From: Battye, Andrew <Andrew.Battye@safework.nsw.gov.au>
Sent: Tuesday, 26 July 2016 4:26 PM
To: Pamela Morales
Subject: SSD 7016 - Borg Panels Timber Panel Processing Facility Expansion - Oberon

Further to the correspondence received from your office regarding the Borg Facility at Oberon then we provide comment as follows:-

STORMWATER MANAGEMENT AND CARPARK

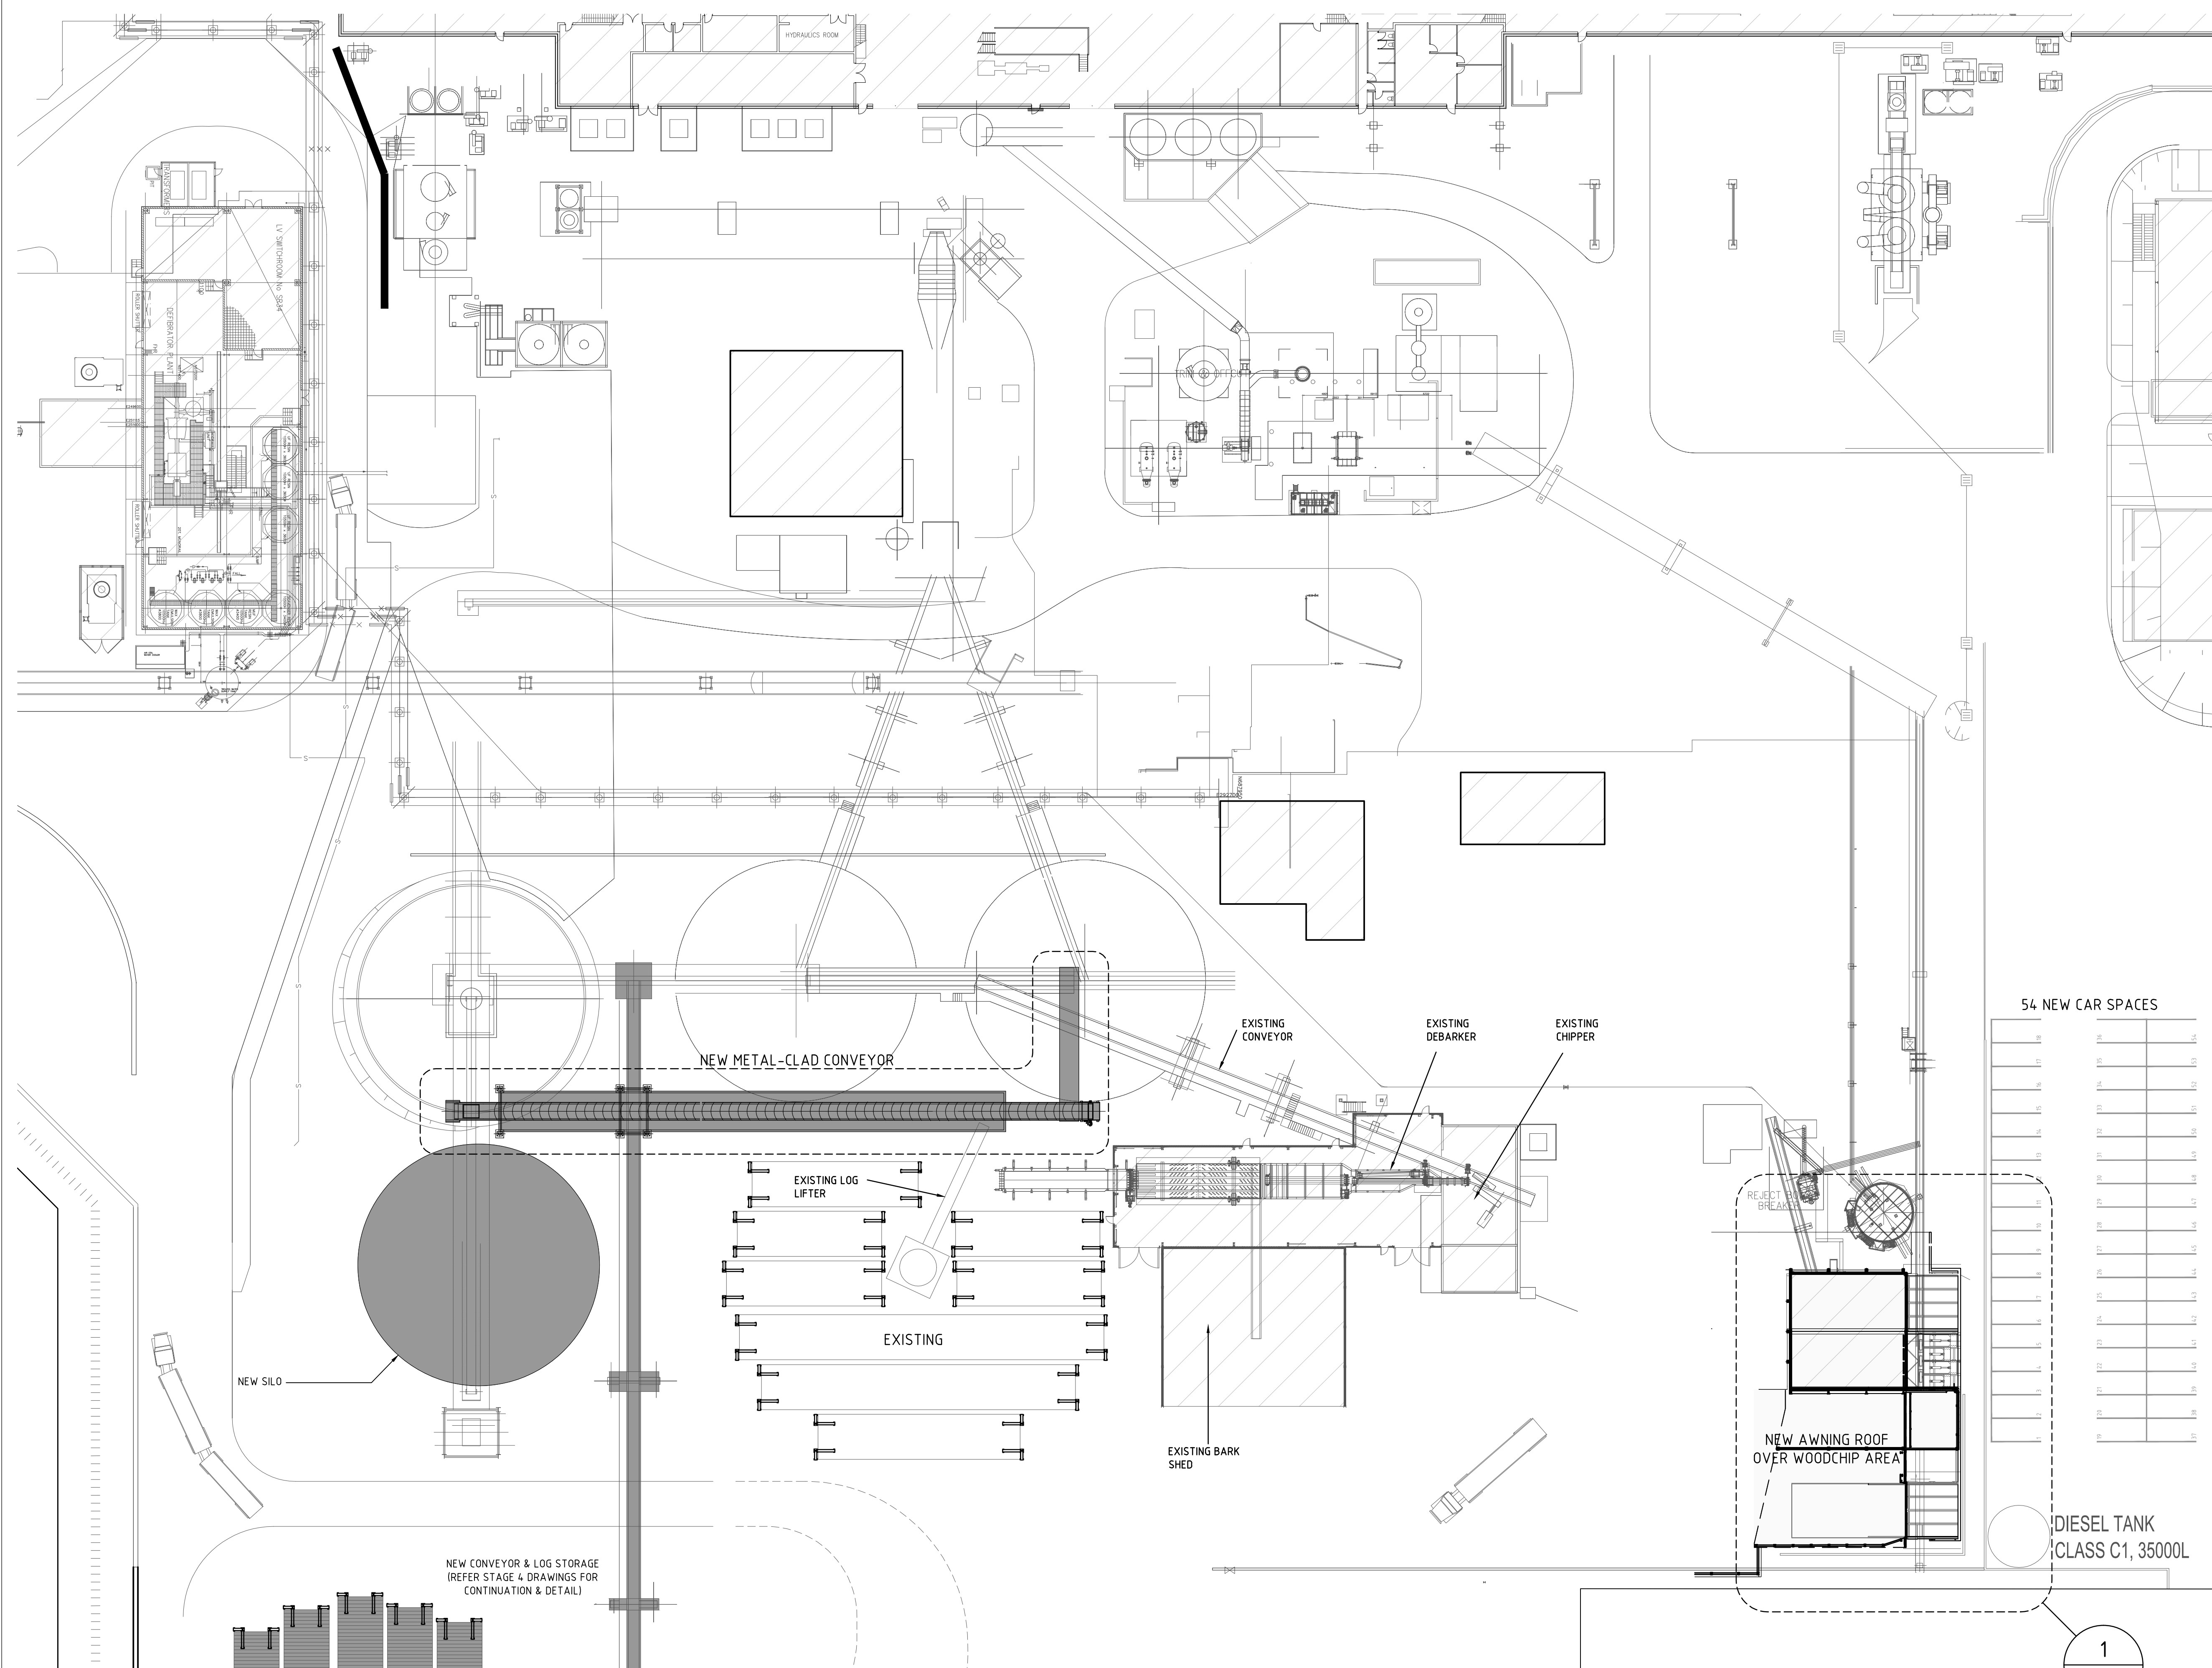
2. SafeWork NSW has concerns regarding the water management and discharges contained within the SEARS doc, Appendix A: Requirements 7,8 & 9, where it appears fixed infrastructure currently directs all Borg surface waters through to the Woodchem dam and swale installations which we believe to be undersized.
